Recommendation Report for Planning Permission

REF NO: P/94/18/PL

LOCATION: Land between Commonmead Barn &
Field View/Farm Gate Cottage
Pagham

PROPOSAL: Erection of 3 No. containers for storage & repair/restoration of cars & boats. This application is a Departure from the Development Plan.

Drg No.: SBS/423/01 AC

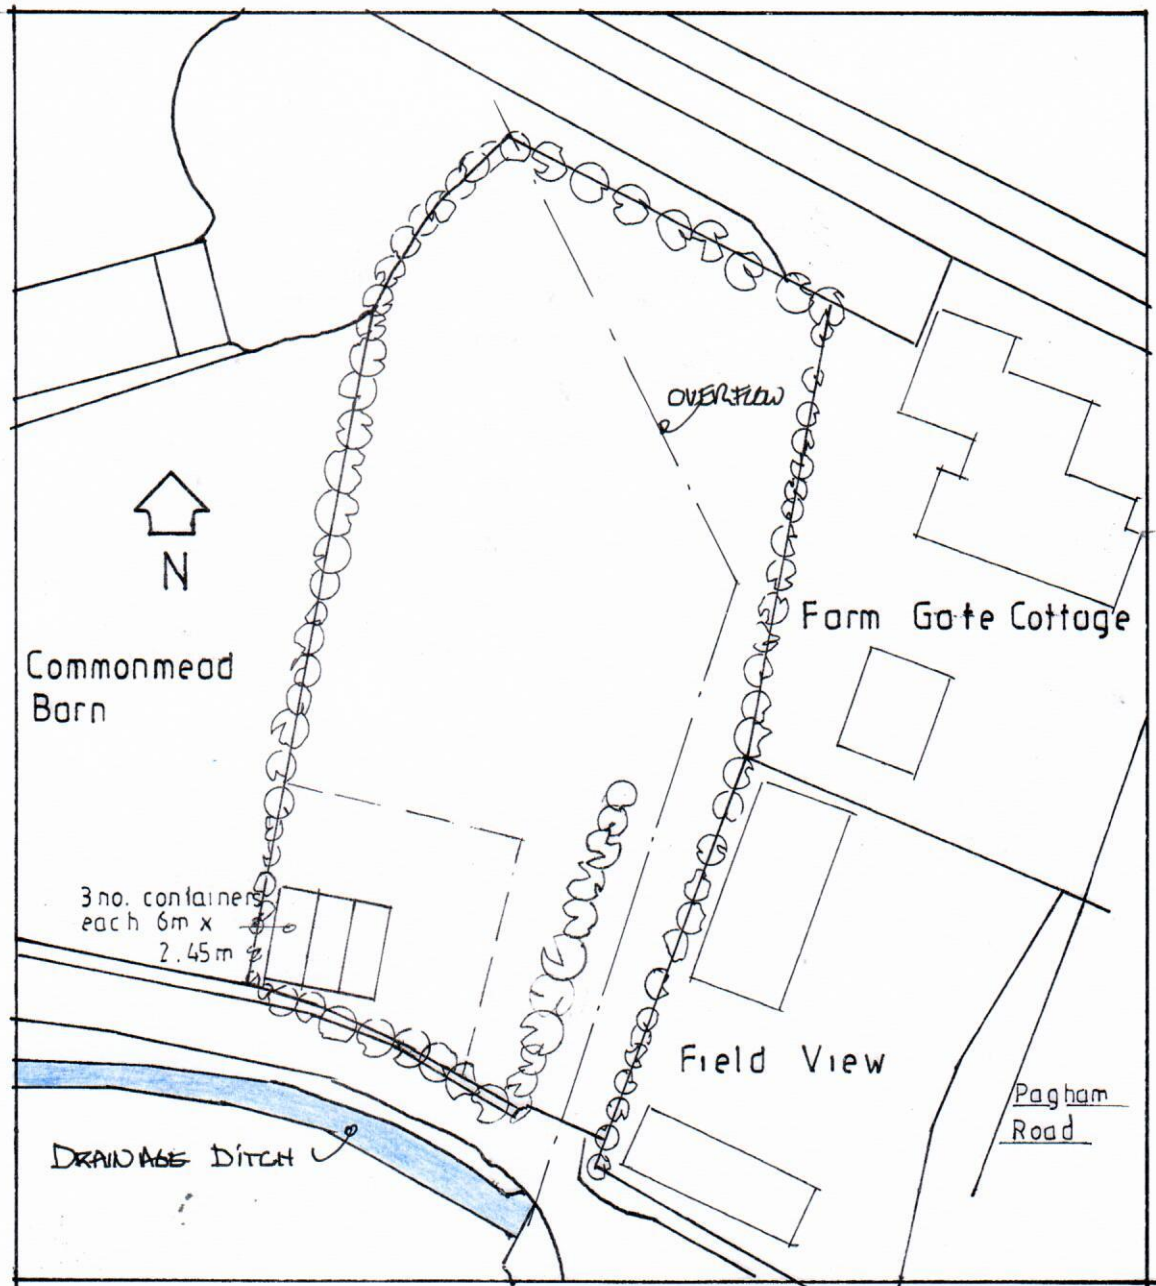
Objection has been raised that the land surrounding Rookery Farm, Grade II listed, overlooks it.

Objection has also been raised that the containers would be unsightly development of countryside.

There is a culverted ordinary watercourse in the area. The exact location of this should be established. Recommends the imposition of a condition.

Officers note that Rookery Farm is a Grade II Listed Building but note that the portion of the field forming the application site does not abut the boundary of Rookery Farm. Additionally the containers would be sited 50+ metres away from the main Rookery Farm Farmhouse. Additionally the proposed containers would be screened by hedging, planting and trees. Therefore, it is considered that the proposed containers would not have a detrimental impact on the occupiers or on the Grade II Listed Building or its setting.

Officers note the modest size and scale of the containers, with a height of approximately 2.45 metres, along with the hedging and planting which would sufficiently screen the proposed containers. Therefore, it is considered that the proposed containers would not have an unsightly and detrimental impact on the countryside.

I am happy to remove our request for the condition for easement to watercourse as the plans and information provided evidence that the proposed containers will not be sited within 3m of the culverted ordinary watercourse.

From an assesment of the submitted plans and the Drainage Engineer's comments, Officers note that the culverted ordinary watercourse (overflow from pond behind site) does not run across the application site and as such would not be impacted by the proposed siting of the containers.
